DR. NORMAN JORGENSEN

WRITTEN REPRESENTATION

HIGHWAYS ENGLAND'S RESPONSE

ADDITIONAL COMMENTS FROM DR NORMAN JORGENSEN

Drawing file: TR010019 / TR010019-003733-Environmental Masterplan Sheet 5.pdf

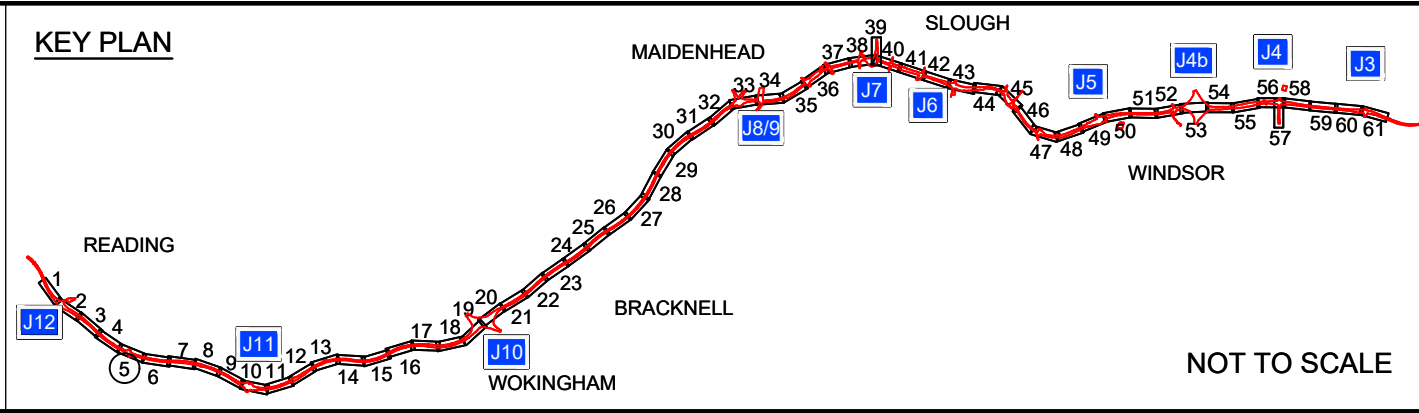
- 1.3 *I believe you are already aware of the houses in Sindlesham near the motorway, however for completeness I will mention these again. This is an area where the plan in the scheme is to upgrade the existing barriers.*

- 1.3.2 The confirmed barrier provision in the Sindlesham area is detailed within Appendix E of the Enhanced Noise Mitigation Study Report (Ref 514451-MUH-00-ZZ-RP-EN-400158); sheet 5 is relevant to this area. This barrier provision has been based on a detailed cost/benefit analysis, undertaken as part of the enhanced noise mitigation study quantitative assessment.

- 1.3.3 The results of the enhanced noise mitigation study proposes to increase the height of the 583m long noise barrier, at Sindlesham, to 3.5m and to provide 314m of new 3.5m high noise barrier in the Mill Lane area. The provision of this mitigation will provide further noise decreases to properties in Sindlesham, in addition to those the negligible to minor noise decreases on Scheme opening (without enhanced mitigation) presented on Sheet 5 of Drawing 12.4 of the ES (Application Document Reference 6-2, APP-266).
